**Rezoning Transportation Analysis**  
**Petition Number: Insert Zoning Petition #2021-213**  
*General Location Identifier: 22706130*

**Revision Log:**

Date	Revision Log:
01/21/2022	First Review (WB)

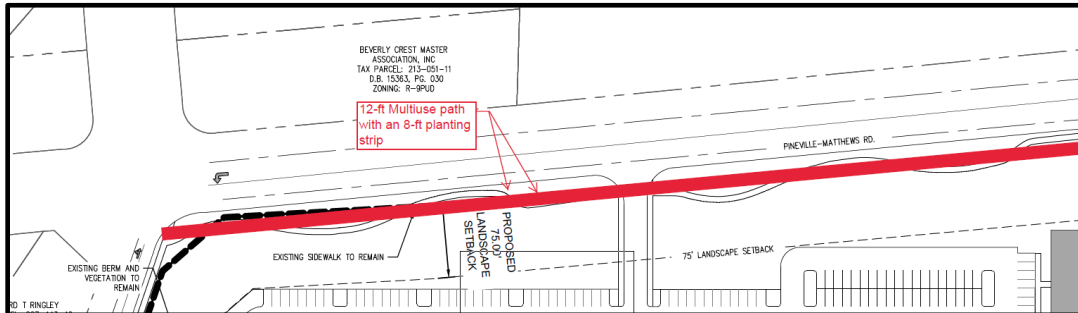
- Revise site plan and conditional notes to commit to dedicate 50-foot right-of-way from the Pineville-Matthews Road centerline. The site plan shall label and dimension the right-of-way from the road centerline.
- Revise site plan and conditional notes to commit to dedicate 36-foot right-of-way from the Hugh Forest Road centerline. The site plan shall label and dimension the right-of-way from the road centerline.
- Site plan and conditional note revisions are needed to commit to constructing two accessible curb ramps on the southeast corner of the Hugh Forest Road intersection per PROWAG and ADA law. Commitments to include all necessary works to bring the pedestrian crossing into ADA and PROWAG compliance, including crosswalk restriping.

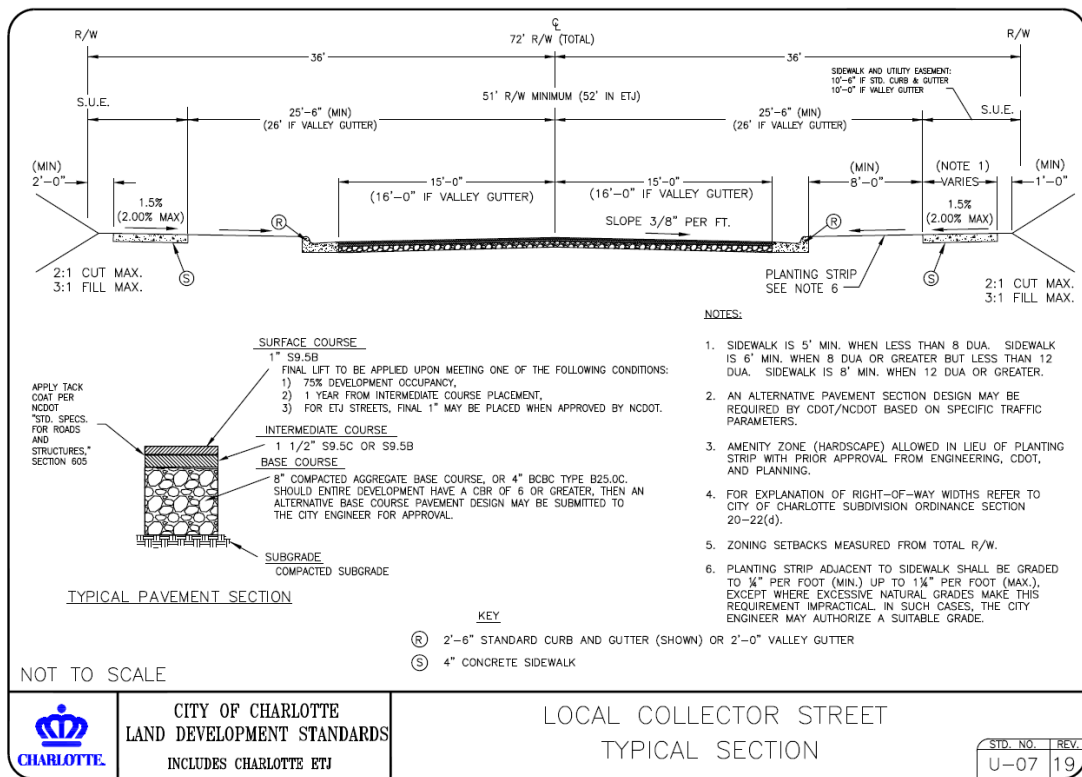
5. Site plan and conditional notes revisions are needed to commit to construct bicycle facilities by installing a 12-foot multi-use path along the site's entire Pineville-Matthews Road frontage in accordance with the Charlotte BIKES Policy.

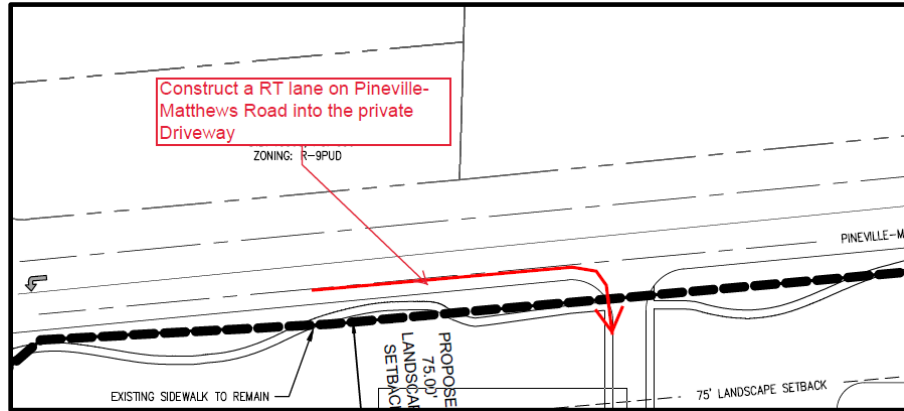
6. The proposed dwelling units exceeds 12 per acre. Per Chapter 20 Subdivision ordinance, site plan and conditional note revisions are needed to commit to construct an 8-foot sidewalk with an 8-foot planting strip along Hugh Forest Road. The wider sidewalk also meets the Charlotte WALKS Policy.

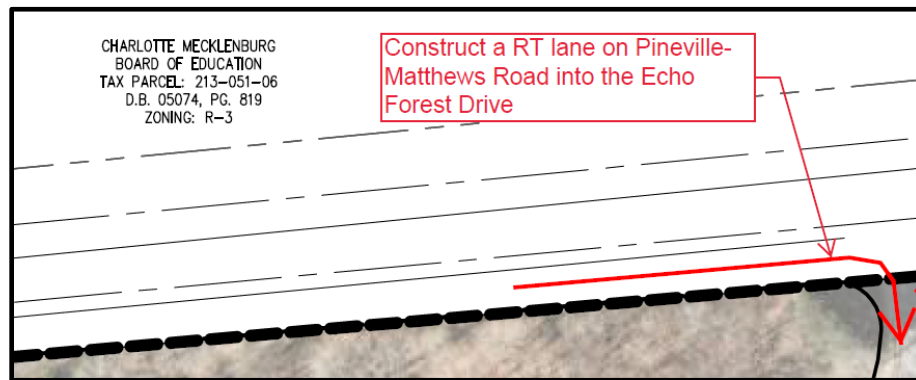
7. Revise site plan and conditional notes to commit to constructing a right turn lane on Pineville-Matthews Road into the proposed driveway per NCDOT standards.

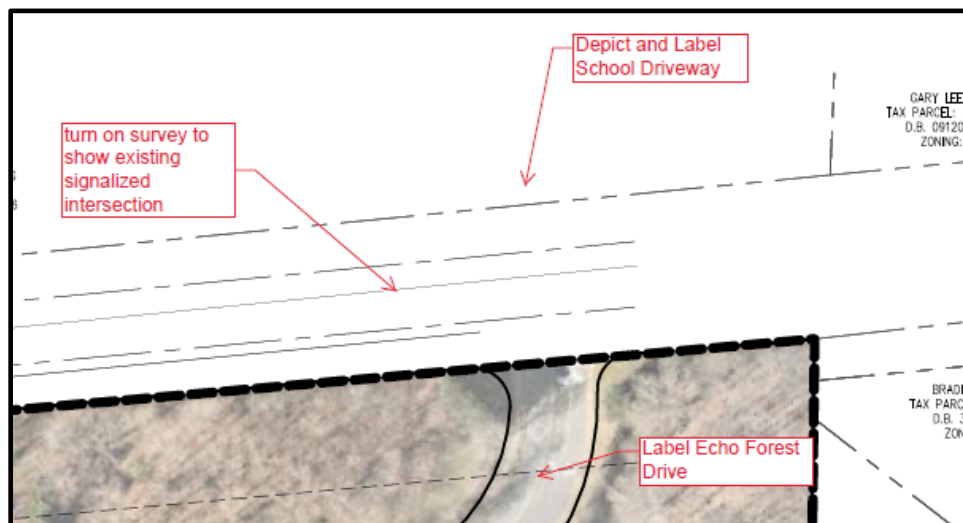
8. Revise site plan and conditional notes to commit to constructing a right turn lane on Pineville-Matthews Road into the Echo Forest Drive per NCDOT standards.

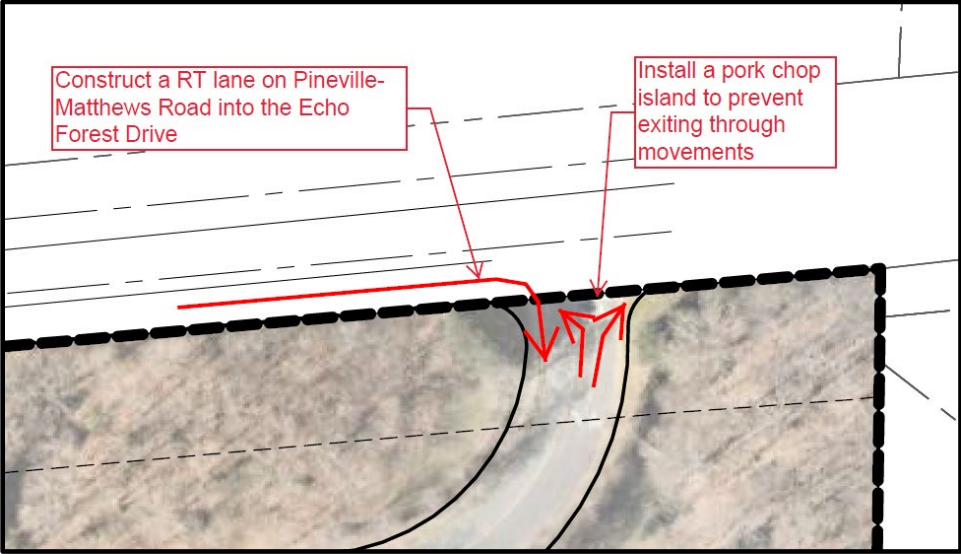
9. Revise site plan to adequately depict and label existing facilities, including the Echo Forest Drive, the signalized intersection at Echo Forest Drive, and the existing School Driveway.

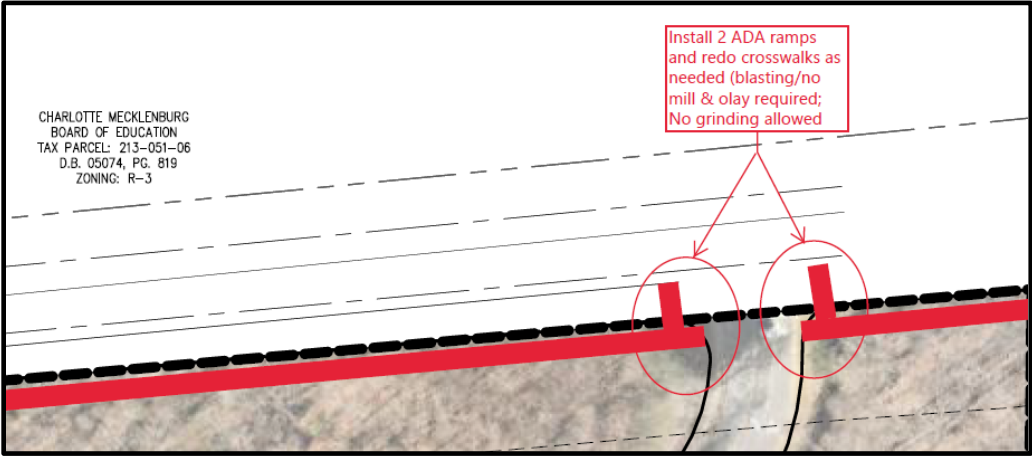
10. The egress movement at Echo Forest Drive shall be limited to 'left out and right out' only to mitigate the increase in traffic at the existing signalized intersection. No northbound through movements will be encouraged. Petitioner to install a concrete channelization island per NCDOT standards to enforce the restricted movement.
